From: Paul Cann <Paul.Cann@arun.gov.uk>
Sent: 30 April 2020 16:05
To: Planning.Responses <Planning.Responses@arun.gov.uk>
Cc: Sarah Burrow <Sarah.Burrow@arun.gov.uk>
Subject: RE: Planning Consultation on BN/30/20/DOC

Comments on surface water drainage (these comments also relate to BN/28/20/DOC);

APPLICATION NO: BN/30/20/DOC

Site Address: Land At Angels Nursery Yapton Road Barnham PO22 0AY

TYPICAL POROUS INLET DETAIL
(MARKED DT ON LAYOUT)

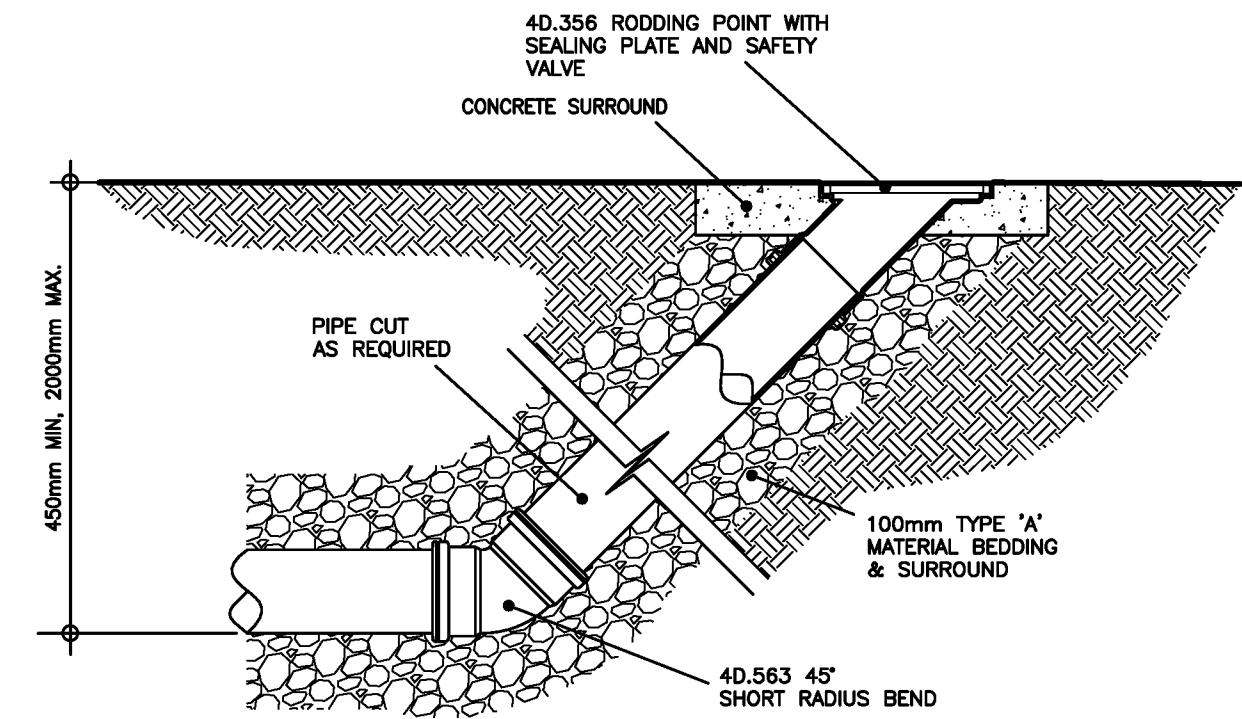
72. Provide pond construction detail including impermeable liner and any necessary anti-buoyancy measures. Floatation calcs to be provided.
73. Provide construction detail distribution tanks on permeable paving outlets.

PRECAST CONCRETE CONTROL CHAMBER

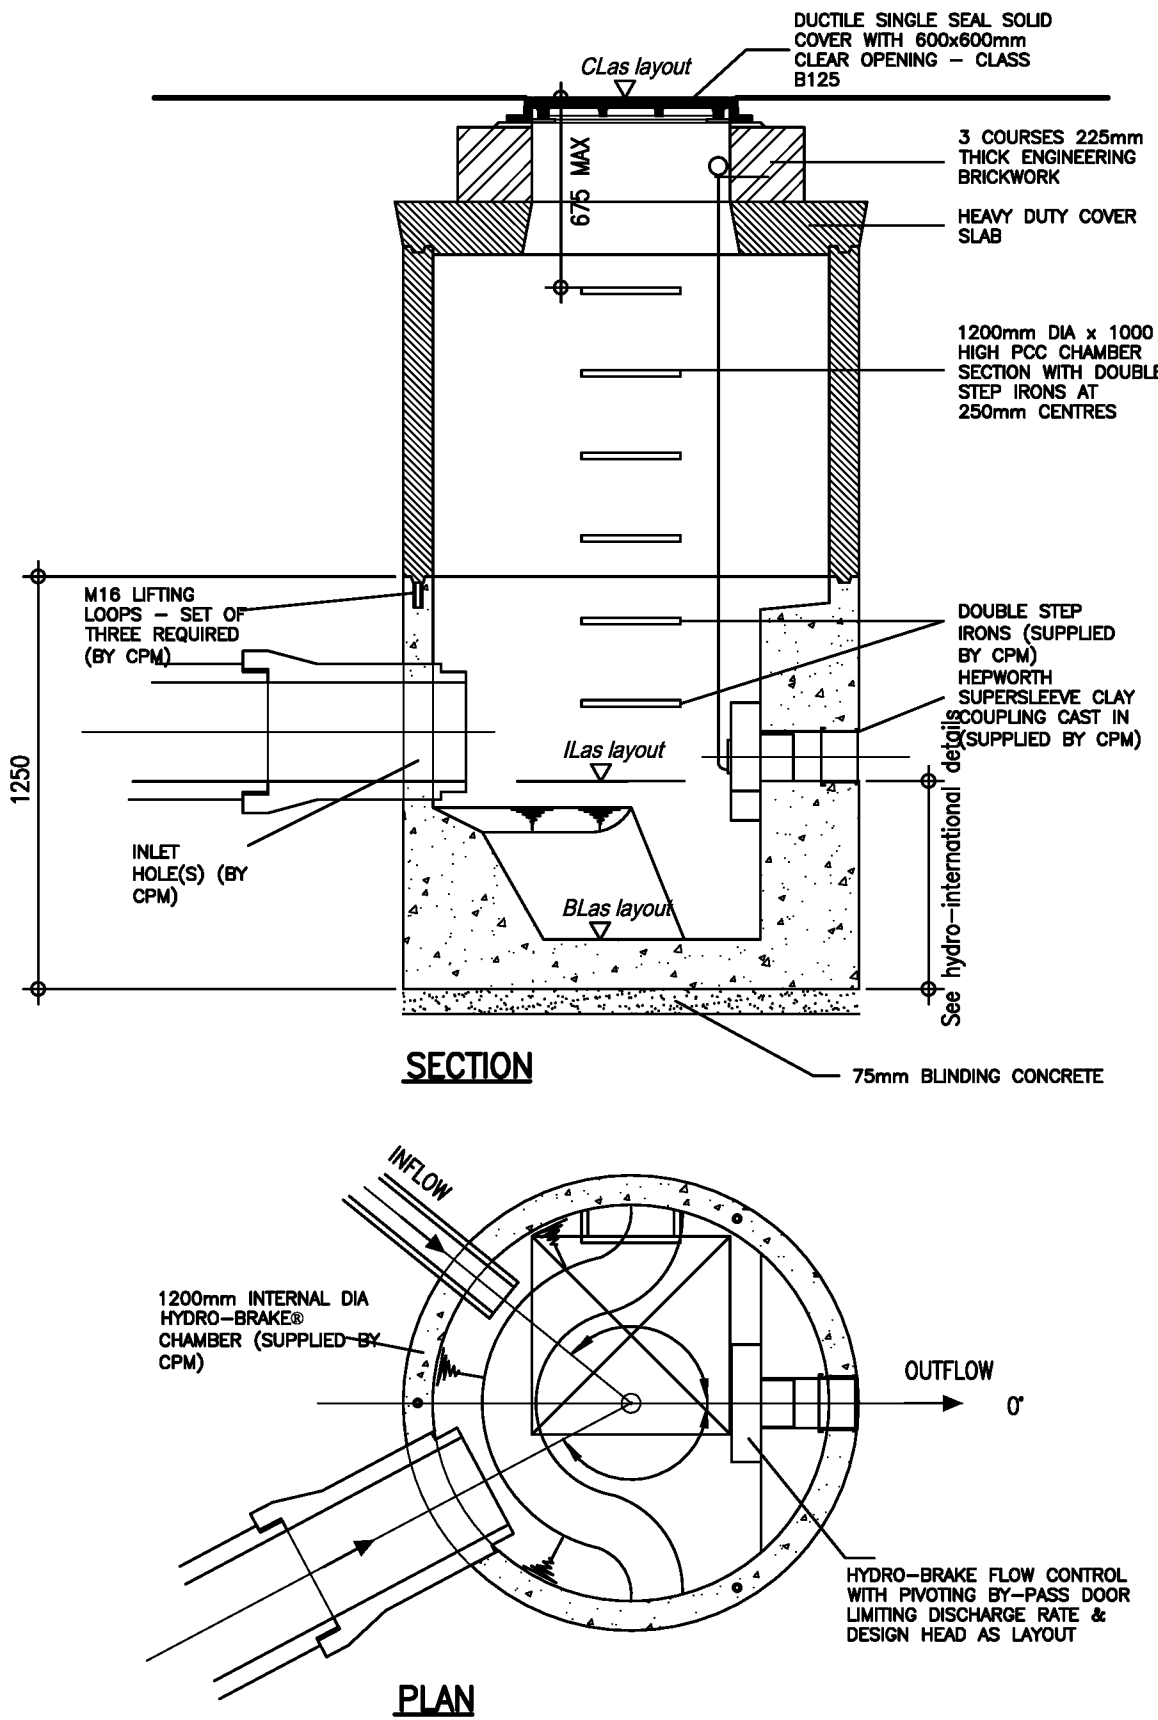
64. Hydrobrake chamber detail – rings to be surrounded in 150mm thick concrete and to be extended down to the bottom of its base. All to be ST4 concrete. Add benching construction notes and include hydro international details referred to.

TYPICAL PRECAST CONCRETE
CATCHPIIT

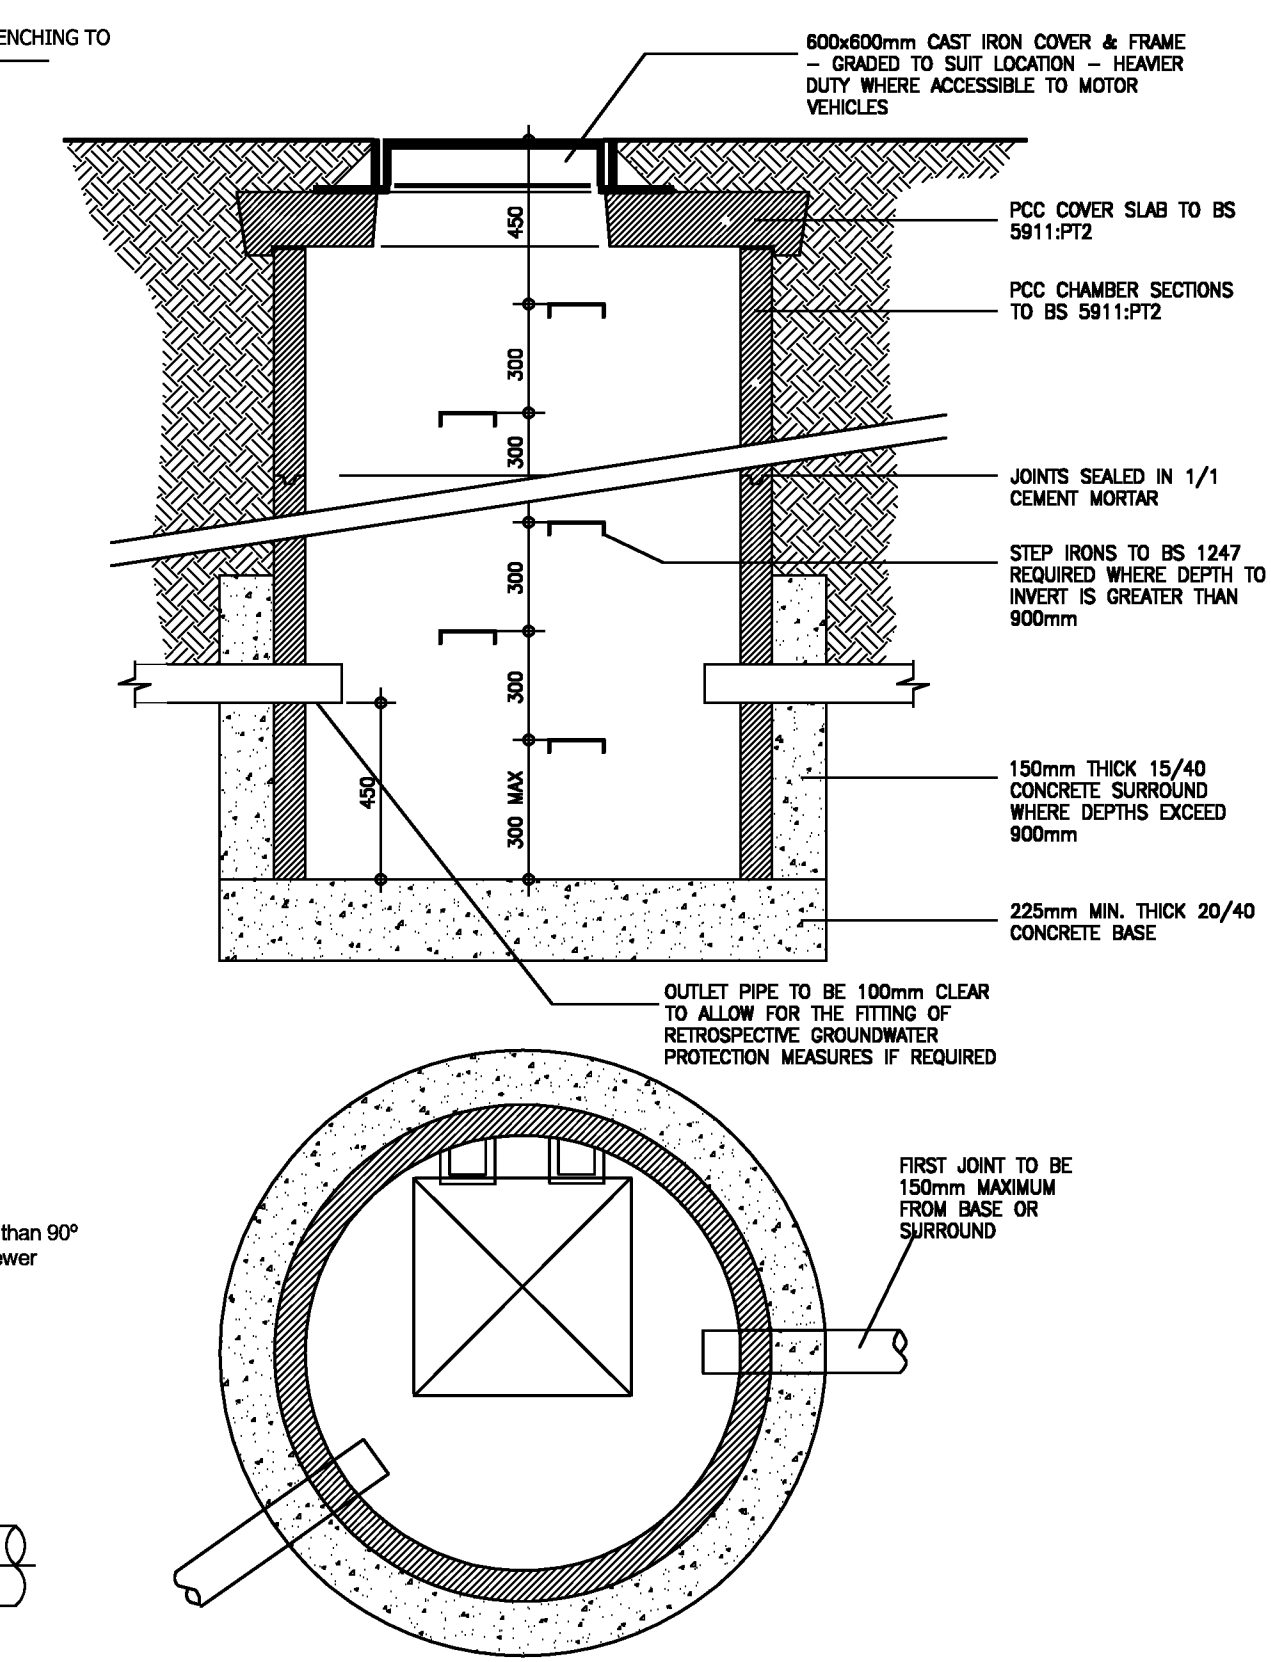
65. PCC ring catchpit detail – unsure if this type is being specified anywhere? If, so detail where and include brickwork under manhole cover/frame and extend concrete surround up to top of cover slab. Specify ring diameter.

66. Provide catch pit detail for all manholes immediately upstream of permeable paving connections.
67. Adoptable outfall headwall detail – remove flat grille and specify cranked including bar spacings, etc. Incorporate Athlon detailed drawing within this drawing. Pond bed level shown as 7.800 but 7.900 on plans.

CONCRETE BAFFLE DETAIL

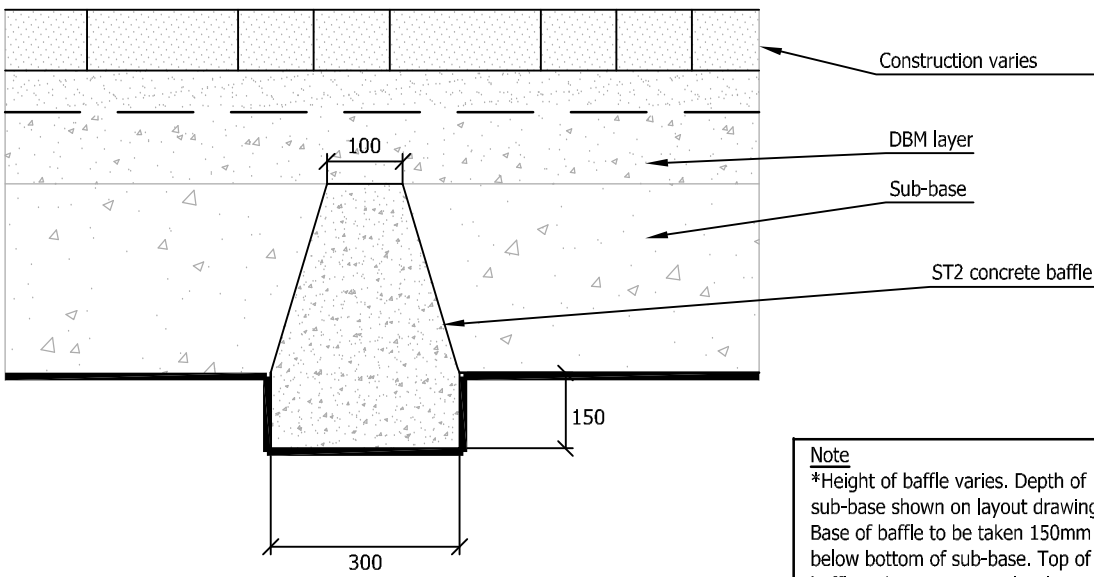
70. Provide sloping formation permeable paving detail.
71. Baffle detail – Make it clear that the top of the concrete is level with the top of the sub base.
